**Tyers Hall Road / Tyers Hill Road
Doncaster Road (A635), Ardsley, Barnsley**

**Designer's Response to
Stage 1 Road Safety Audit**

Report Ref:	9246-003-01		
Author:	Peter Maurice	Date:	26 February 2020

Scale 1:500 @ A1	Drawn By LOB
Drawing Size A1	Checked By PJM
Date Sept 2019	Approved By PJM
Drawing Number 9246/006	Rev A

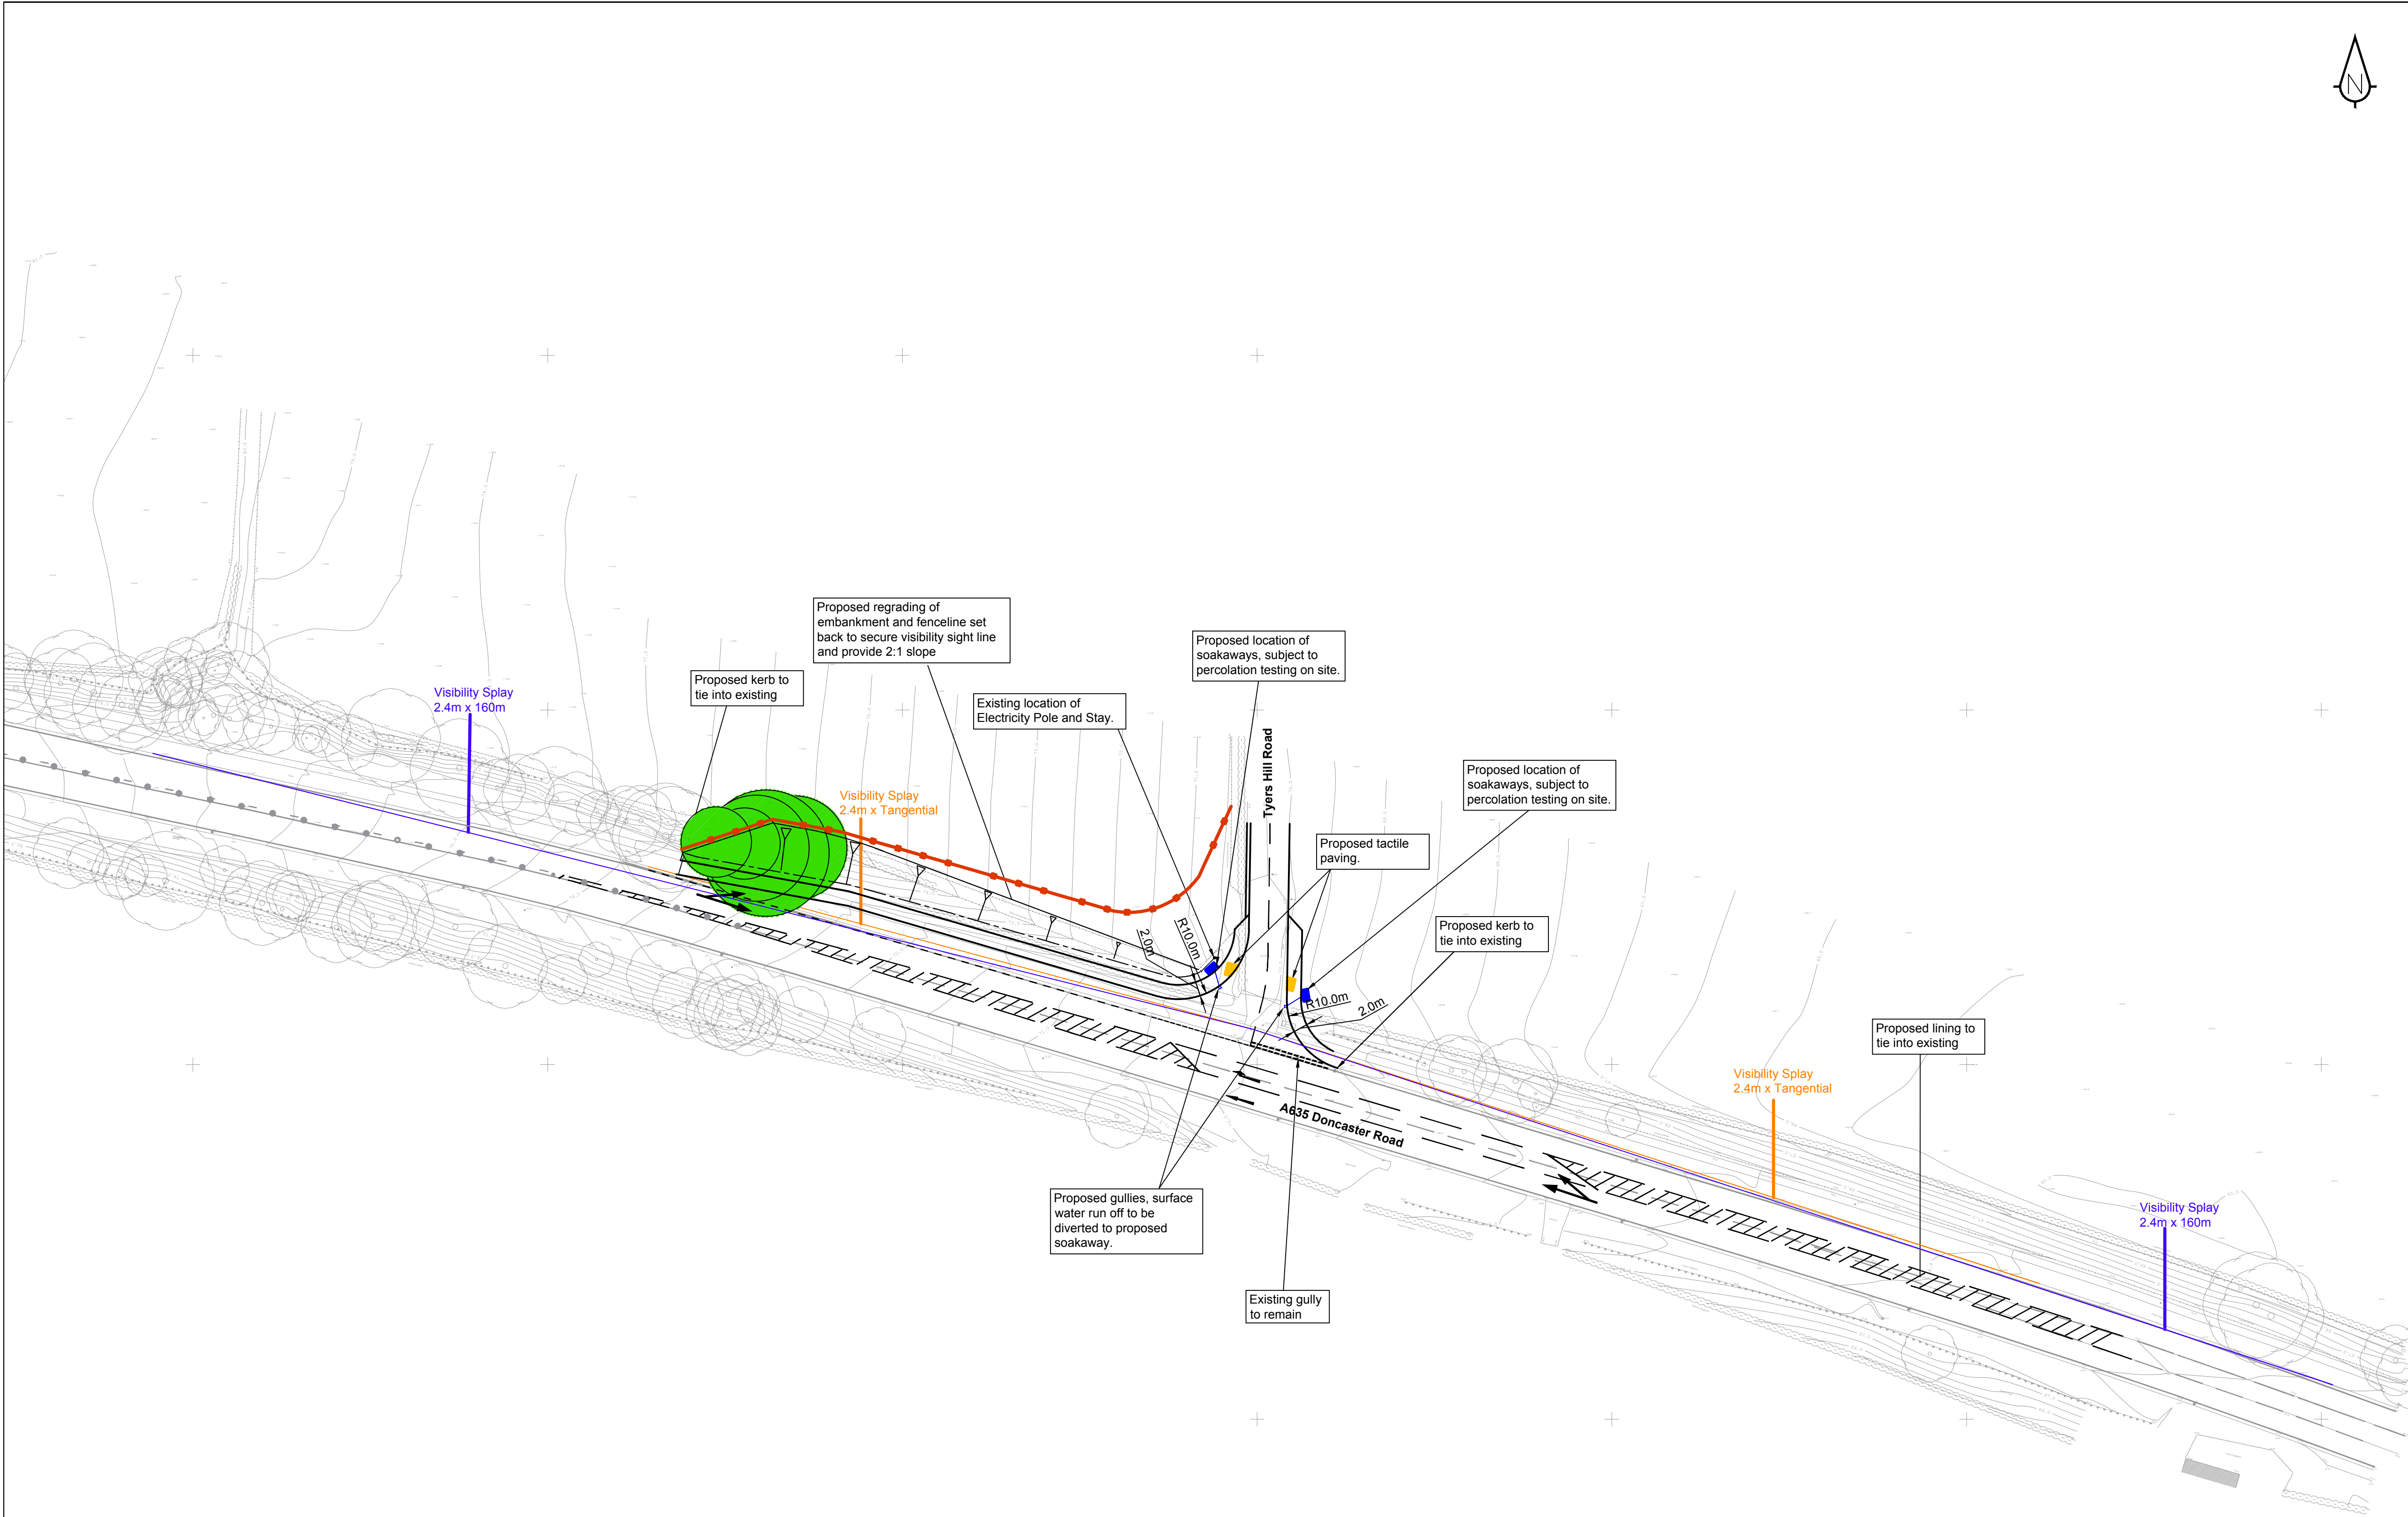
A1.4.2	Problem	Drainage
	Location	Improved access (Tyers Hill Road)

No detailed drainage proposals have been provided for the Stage 1 Audit. However, there is an existing gully on Doncaster Road just to the east of the existing access which will need relocating adjacent to the kerb line as this would be in the wheel track of vehicles turning left on to Doncaster Road. Surface water from the access will need to be intercepted before it discharges on to Doncaster Road. It is important that appropriate drainage of the carriageway surface is provided as this could result in skidding and loss of control incidents whilst turning or braking when the surface is wet and lead to collisions between vehicles at the junction.

Introduce new gullies / drainage to intercept surface water on the access and Doncaster Road.

The designers accept the recommendation of the Audit Team and will amend the drawing accordingly.

A1.6.2	Problem	Public Utilities / Service Apparatus
	Location	northern side of Doncaster Road at Access

No detailed information about existing services have been provided for the Stage 1 Audit. There is an existing electricity pole with stay on the west side of the existing access and overhead cables running diagonally across the new junction. Because of the proposed widening for the deceleration lane and the resultant set back of the footway the existing stay / pole may be in the proposed footway / carriageway. If situated in the footway this could create a trip hazard for pedestrians using the proposed footway or an obstruction in the carriageway.

Adjust the position of the stay so that it does not lie in the footway or the pole in the carriageway.

The designers accept the recommendation of the Audit Team, and will check / advise the Project Sponsor if the pole and stay needs relocating and modify the drawing accordingly.

A4.2.2 Problem Pedestrians

The Road Safety Audit Brief indicates that dropped kerbs will be provided at the junction. Drawing (9246-002 Rev C) does not show the proposed location for the dropped crossings. These should be positioned so that there is inter-visibility between pedestrians and left turning vehicles and the crossing length is not excessive as this could lead to pedestrians straying from the direct route between the crossing points creating potential conflicts with vehicles.

Review the future pedestrian desire lines and provide dropped kerbs with tactile paving in appropriate locations with inter-visibility.

The designers accept the recommendation of the Audit team and will amend the drawing accordingly.
